DRB Application No.: 05DRB-00499 (P&F)	Project # <del>1004236</del>
Project Name: ALVARADO GARDENS UNIT 1	
Agent: Precision Surveys	Phone No.: 8565700

DEVELOPMENT REVIEW BOARD – SPEED MEMO

DRB CASE NO/PROJECT NO: 100~~4236~~  
4236

Development Review Board Comments

Plat of
Lots 25-C and 25-D
Alvarado Gardens, Unit 1
Albuquerque, Bernalillo County, New Mexico
March 2005

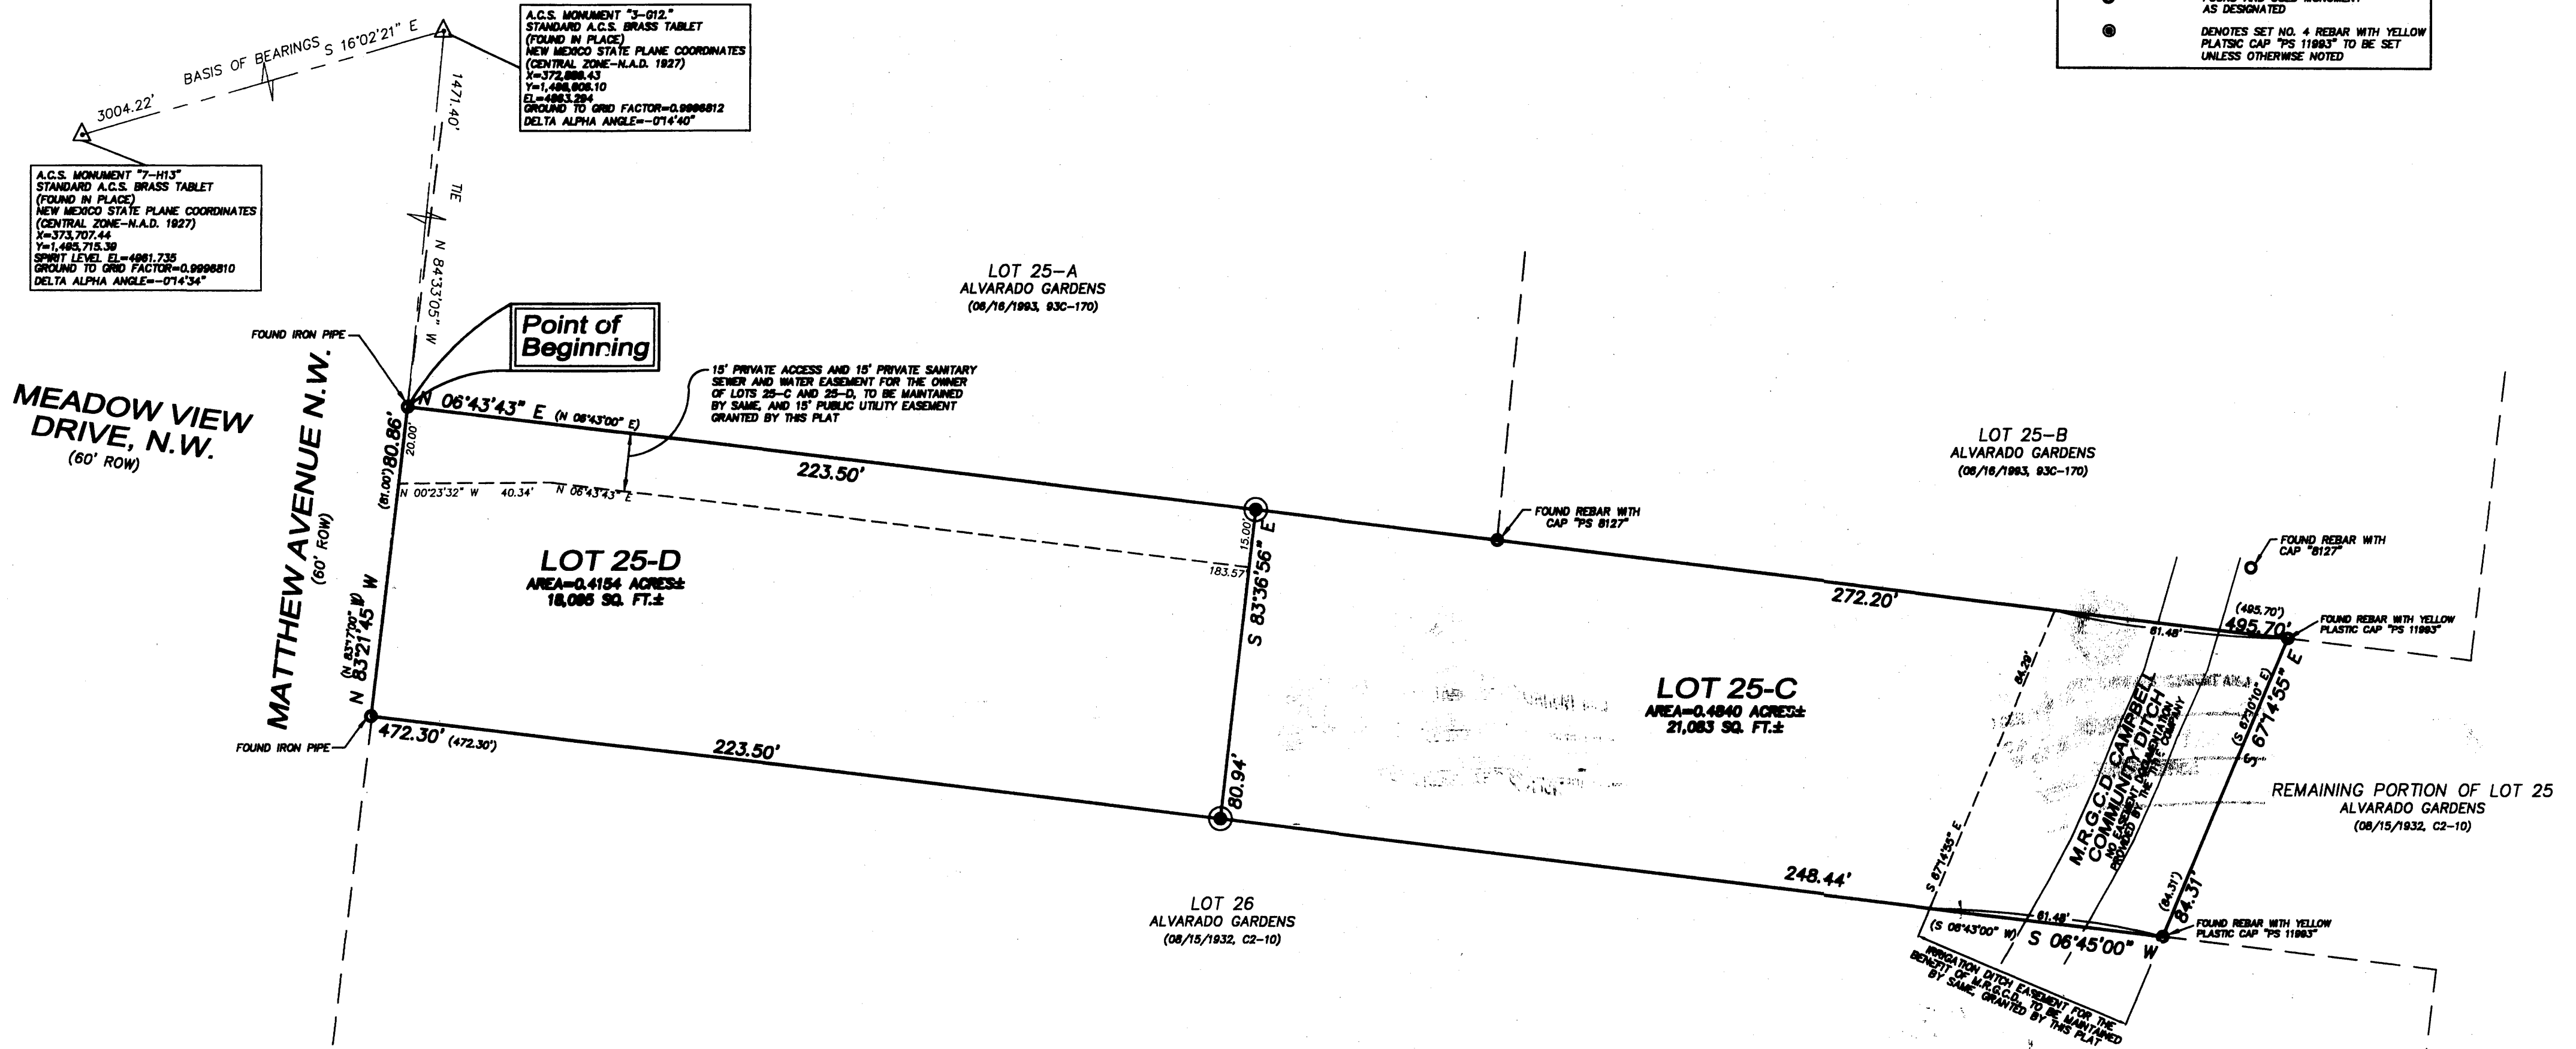
MRGCD sign off is required prior to approval.  
An easement to MRGCD for the Campbell Ditch is required prior to approval. ] Sign-off Received
